Subject: RE: Planning Re-Consultation on: BN/98/21/DOC

Thank you for reconsulting us. We have the following comments on conditions 10 and 11.

Condition 10

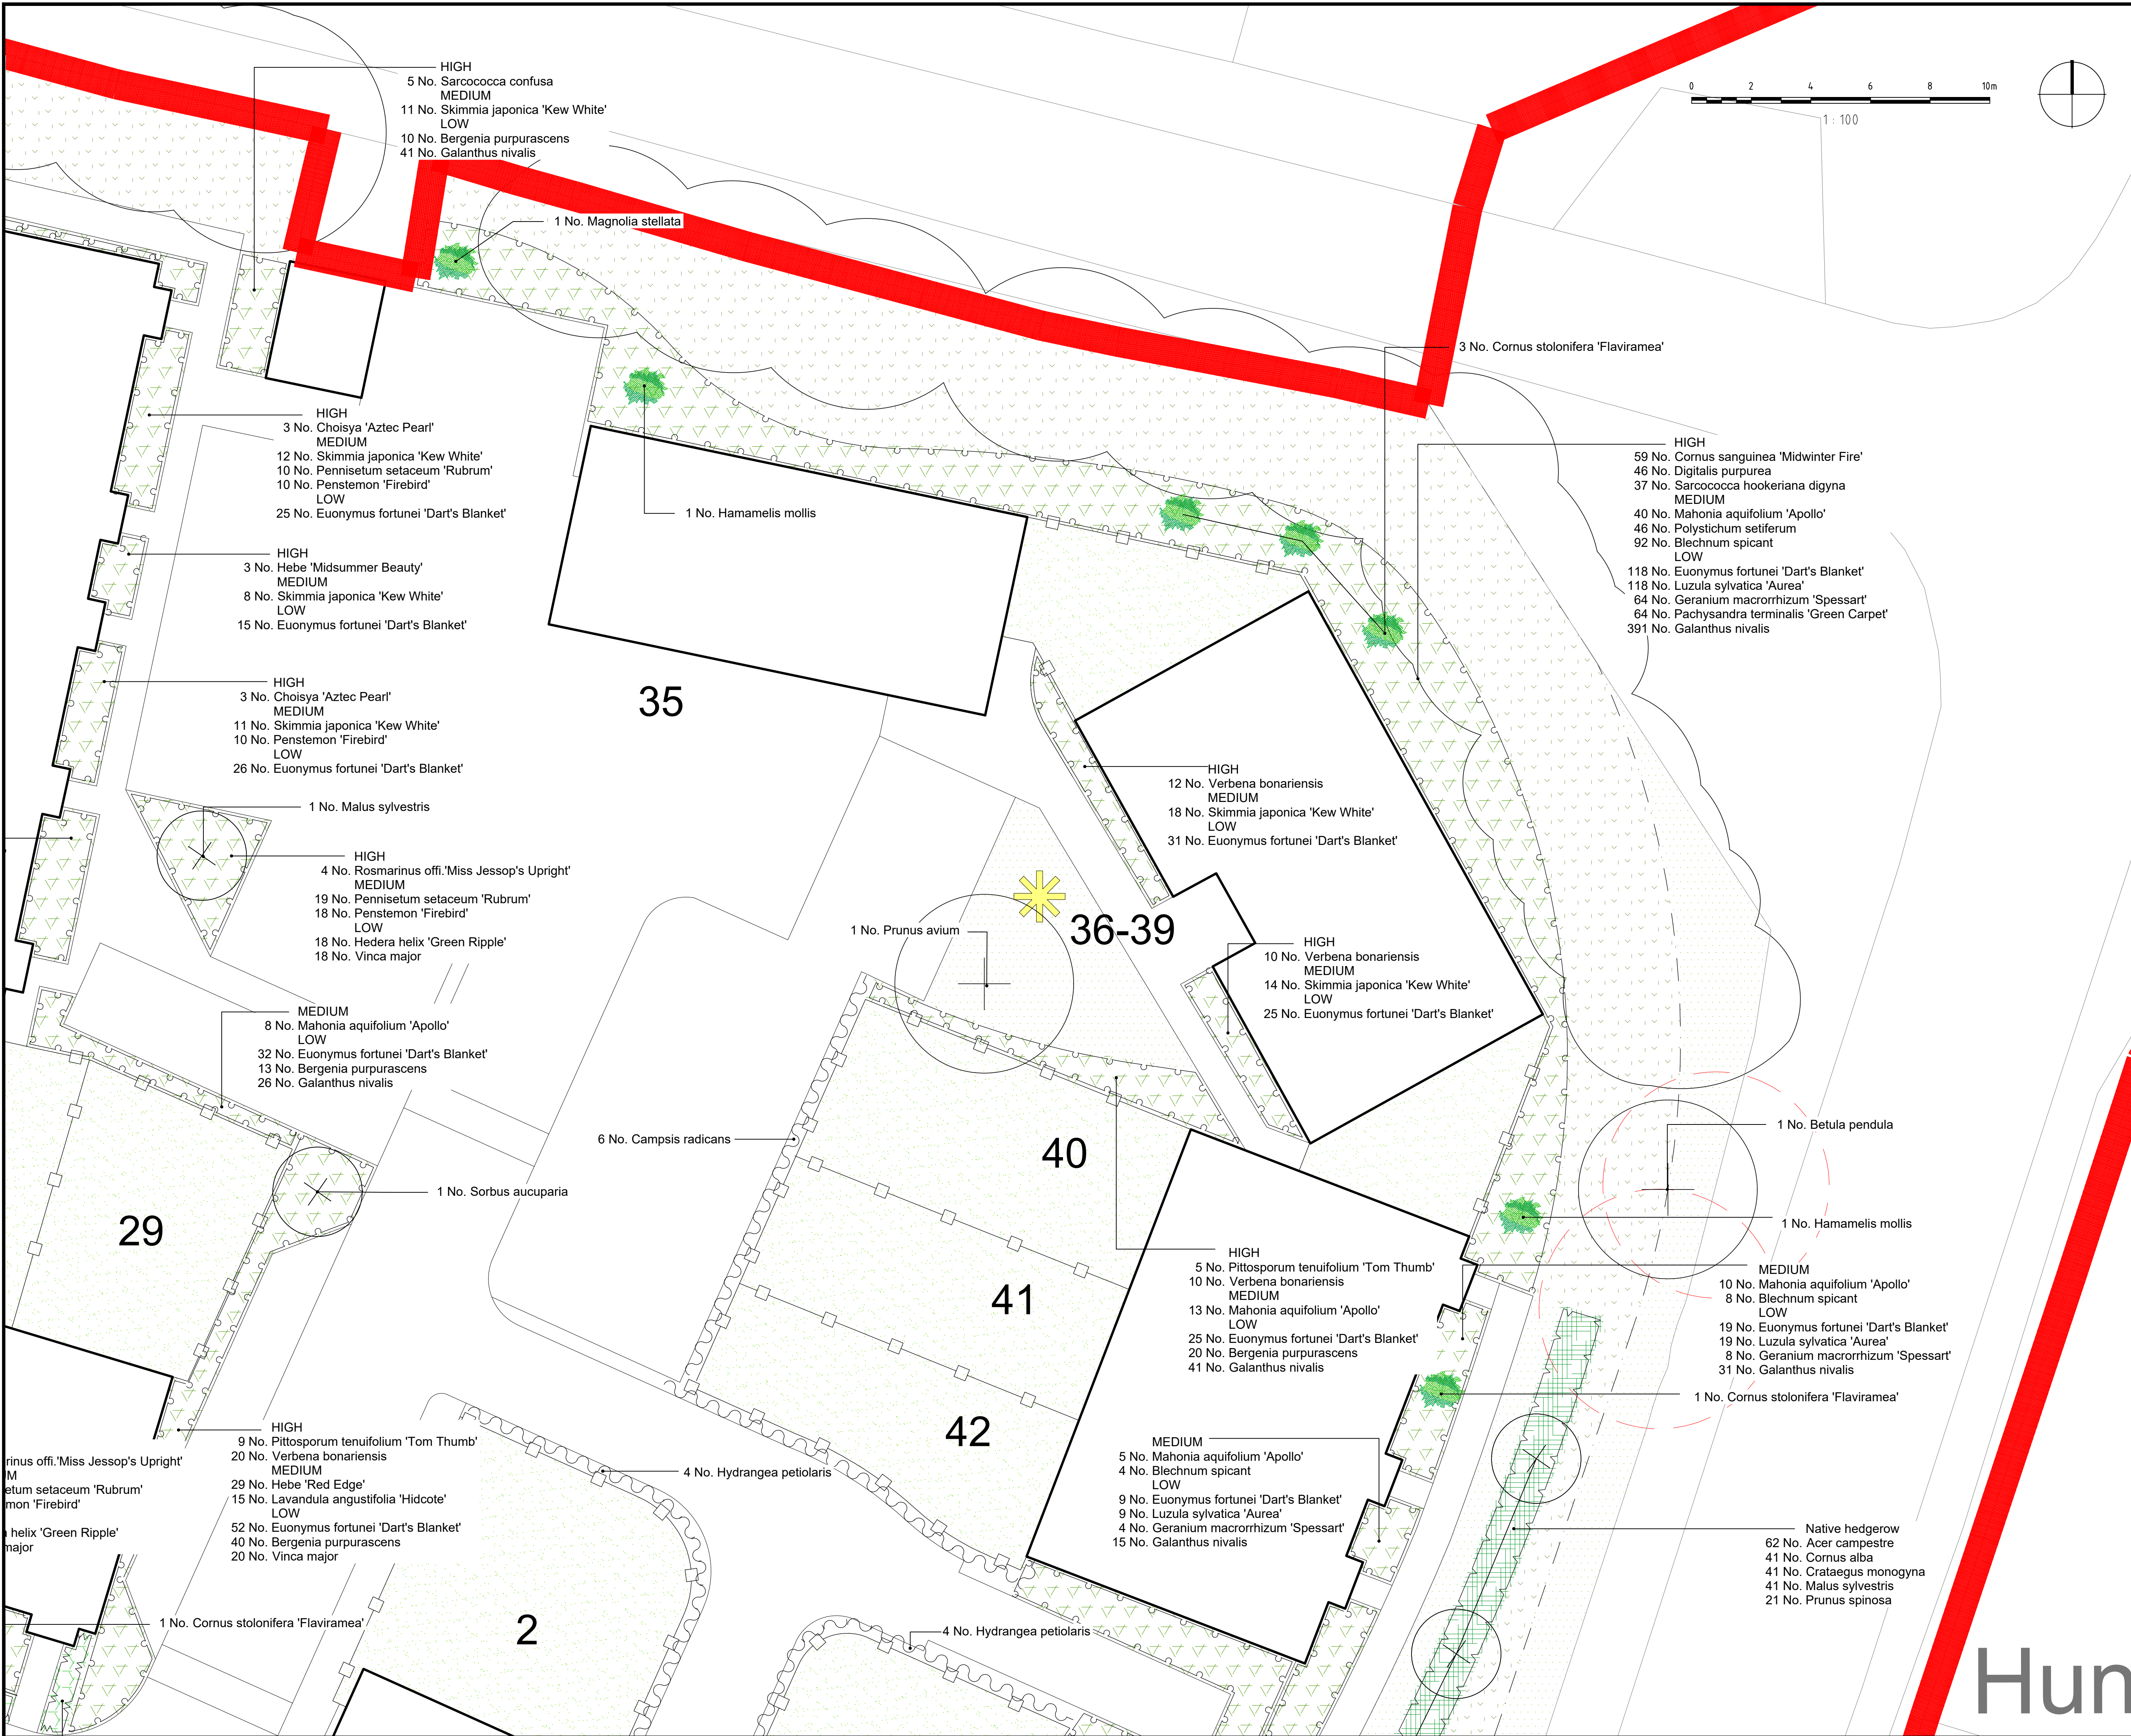
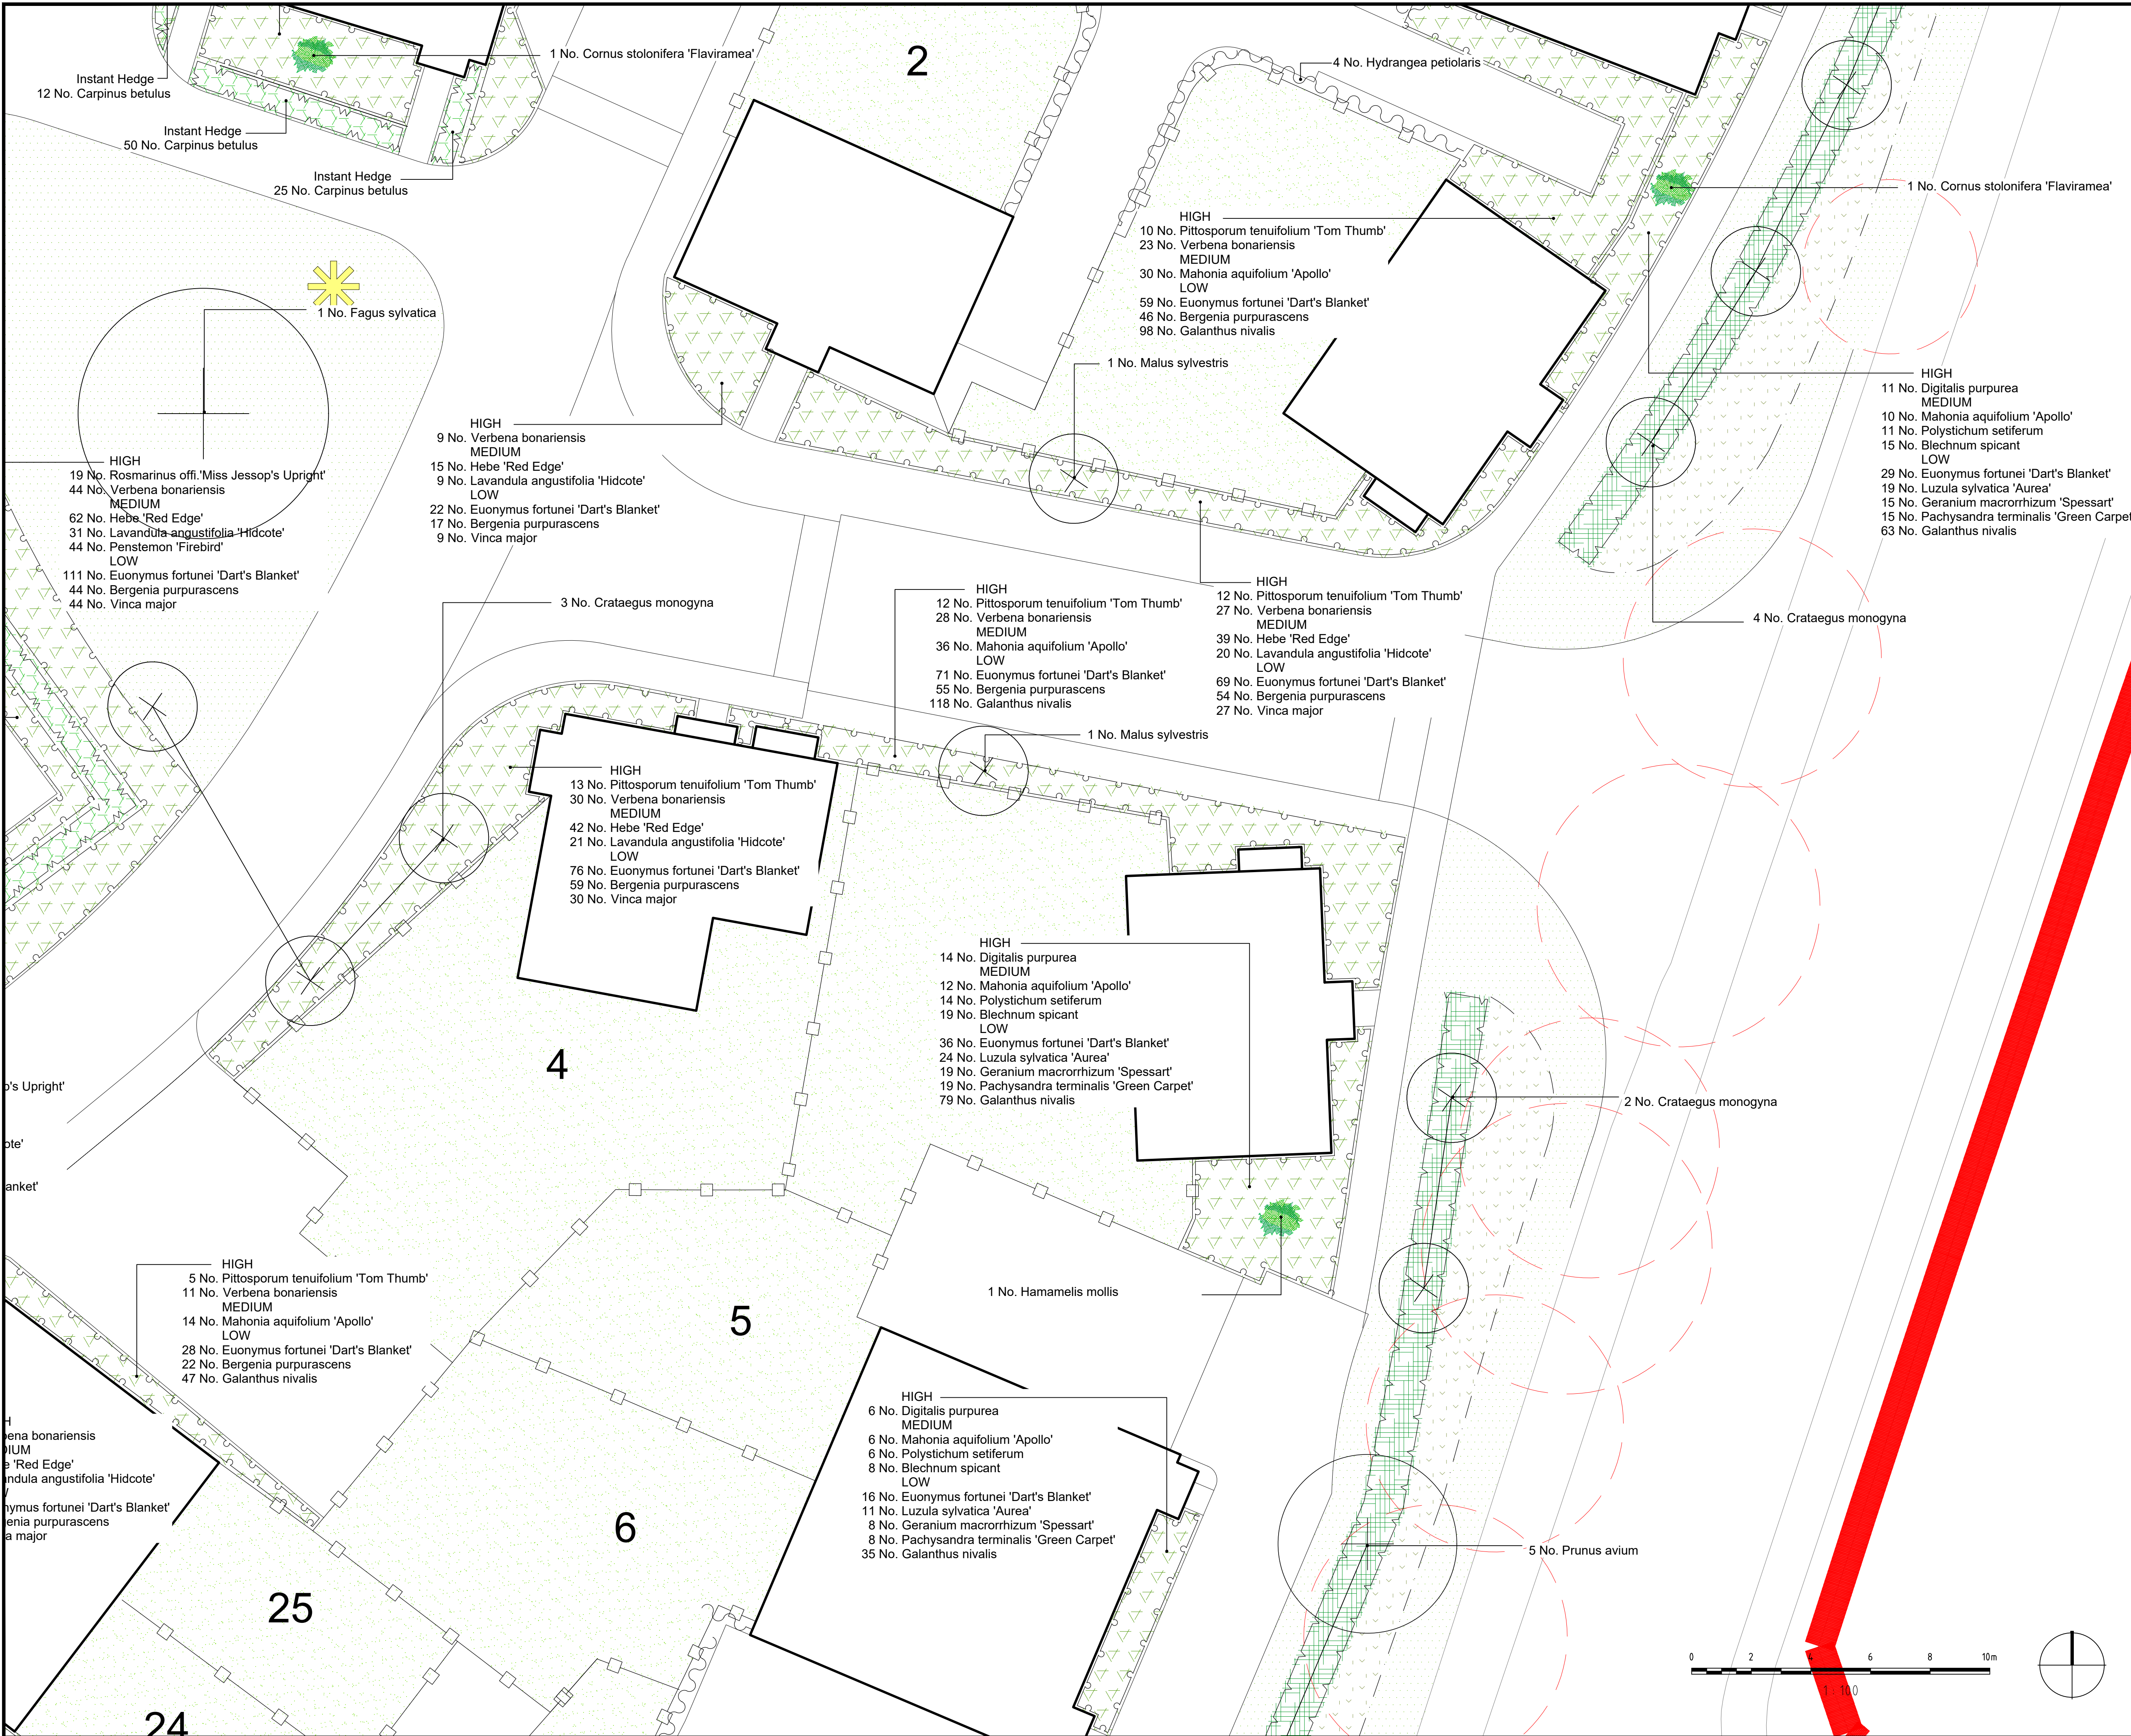
15. There is still conflict between planting plans and drainage layouts, i.e. trees over/ very close to infiltration crates.
16. Please re-consult Porstmouth Water regarding condition 10 now that proposals have crates as low as 2.57m depth.
